WISWELL PARISH COUNCIL

Planning Application No: 3/2012/0739

Outline planning application with all matters reserved for up to 13,000 sq.m. of mixed use class B1, B2 and B8 employment floorspace with access and assorted landscaping Land north of Barrow Brook Business Village, Barrow, Clitheroe, Lancashire

PROPOSED DEVELOPMENT PLAN

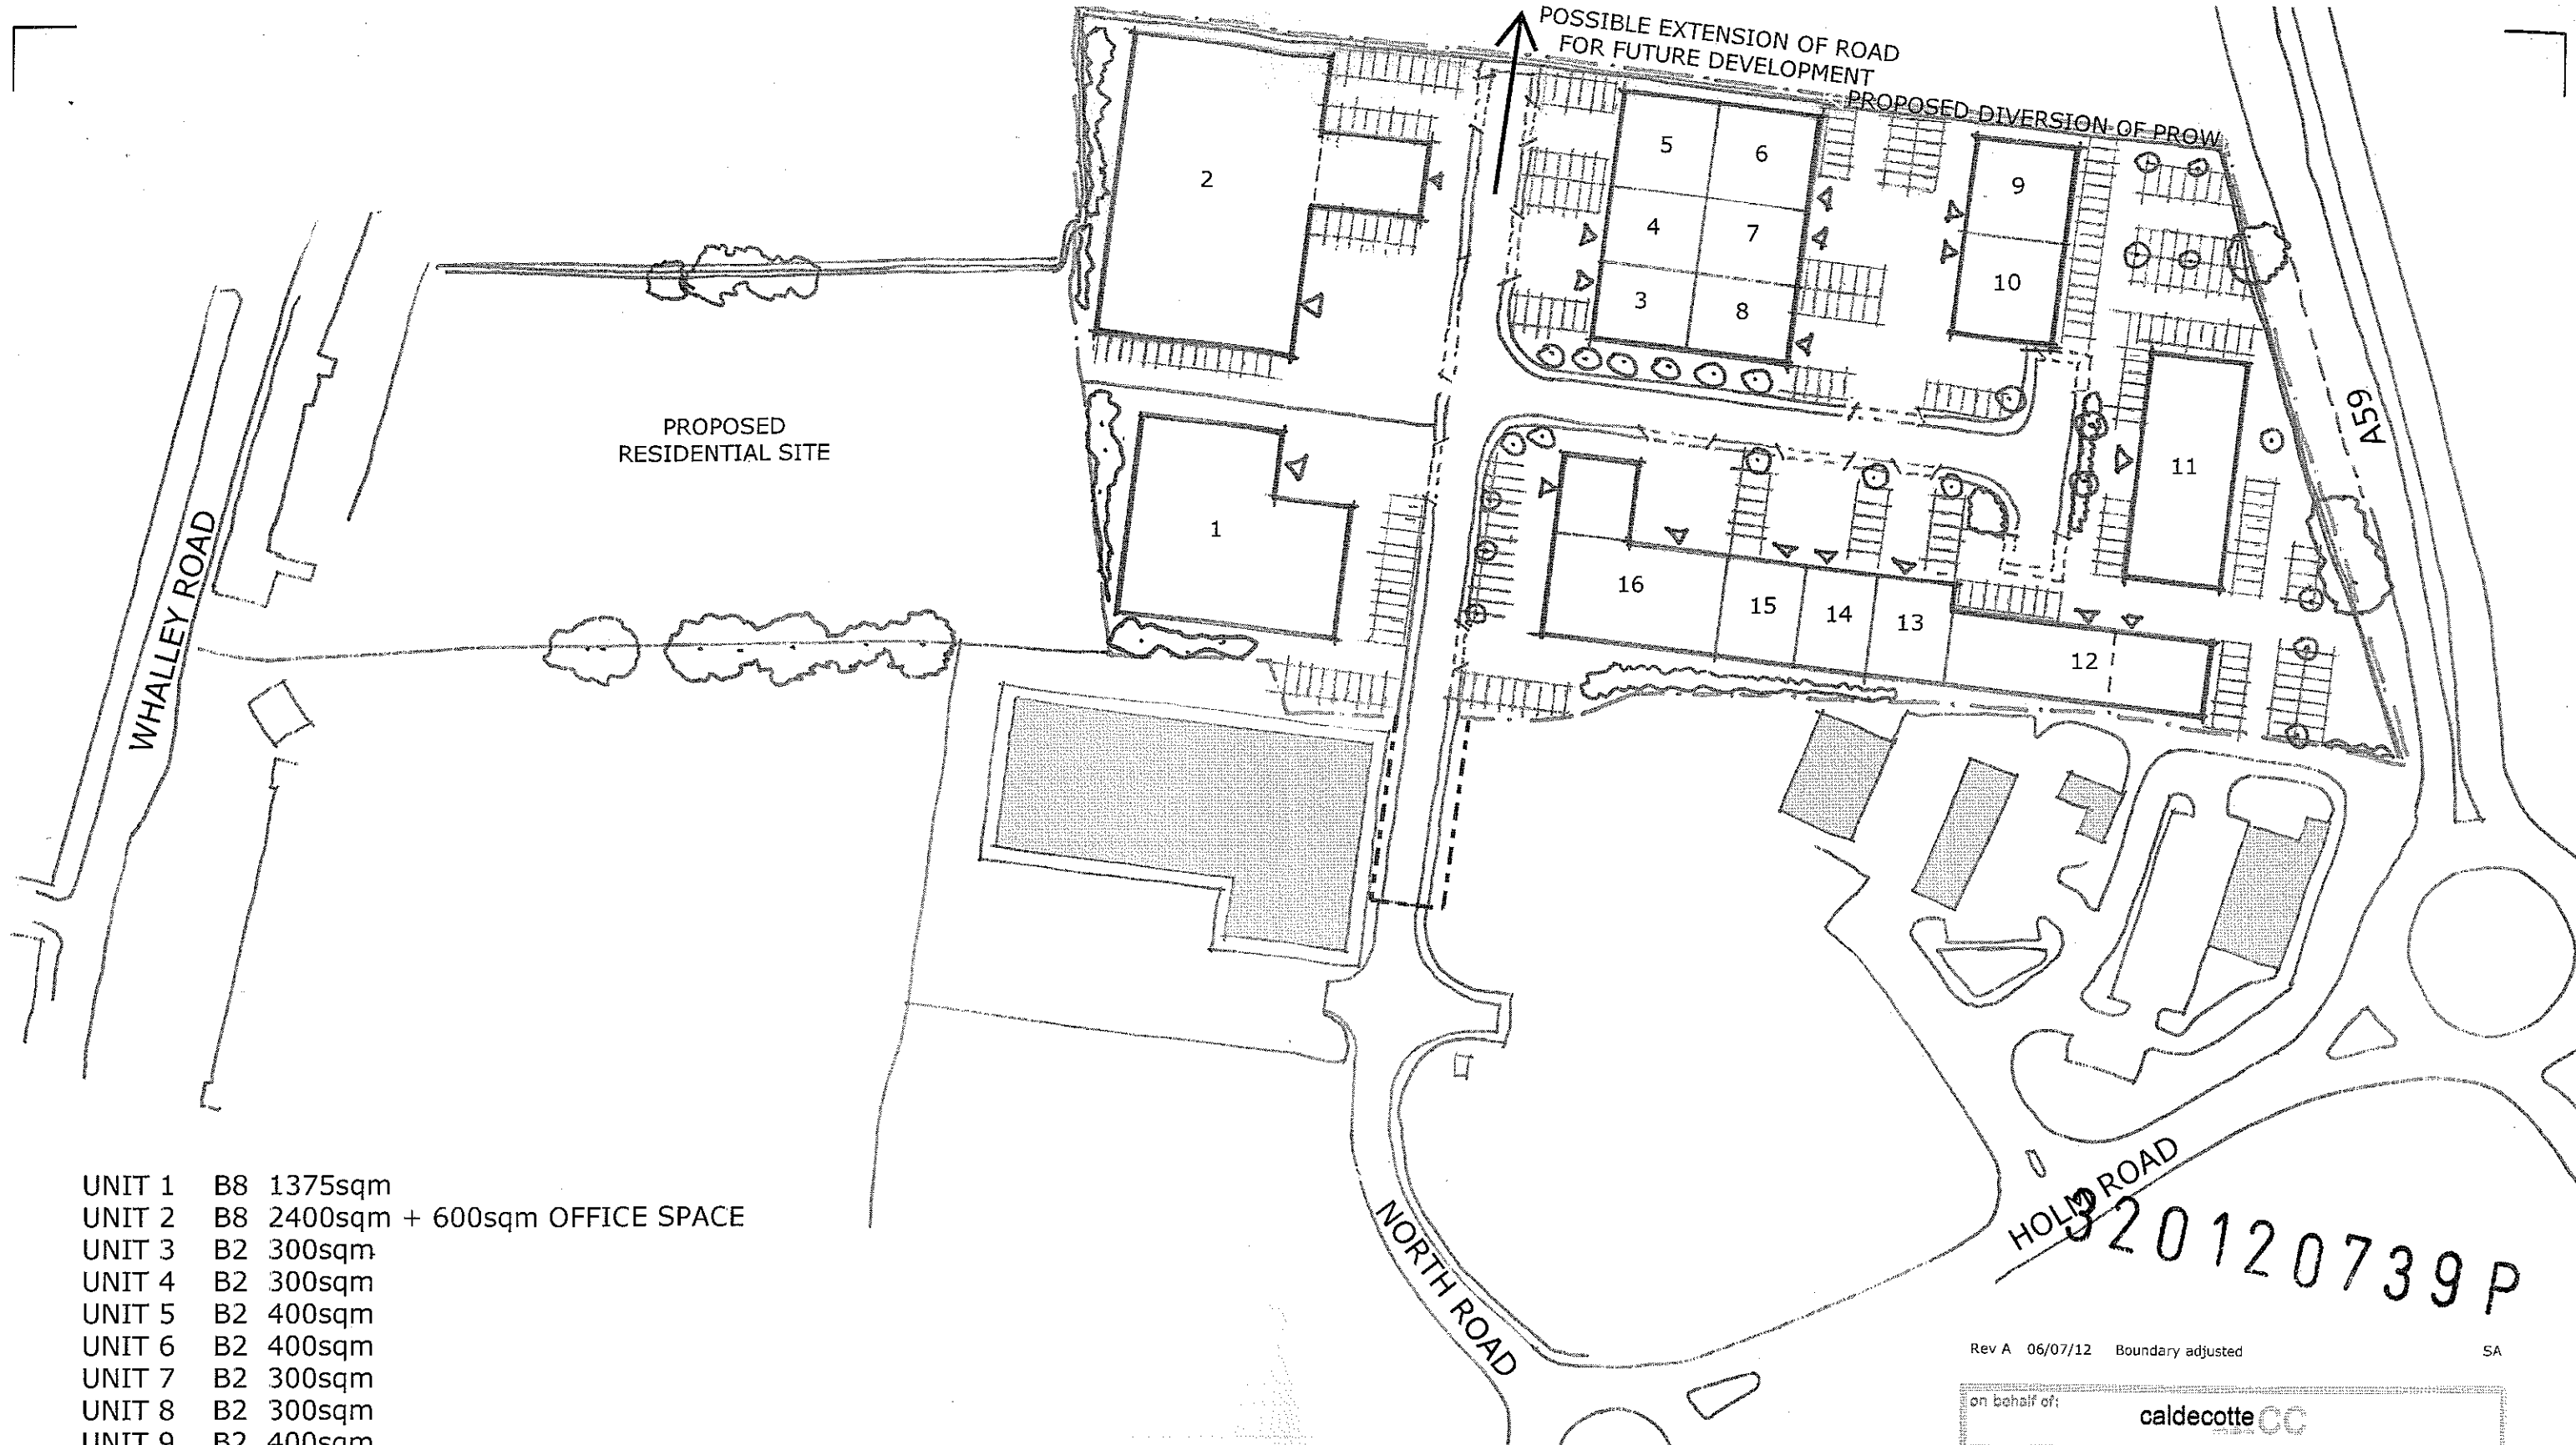
5. Perhaps planning permission should be refused until the results of the Core Strategy are published.
6. Members are concerned by the layout of the proposed development and the close proximity of the large warehouses (1 and 2) which are in full view of the houses at Old Row and Barrow Primary School. The warehouses would be an eyesore, be intrusive in a rural environment and have a negative impact on residential amenities.

9. Members are concerned that the public footpath which runs through the proposed site appears to have been moved around the sites boundaries.
10. On the proposed site map, an arrow is shown on the road stating 'possible extension of road for future development'. Does this mean that even more land is to be opened up for some sort of development?
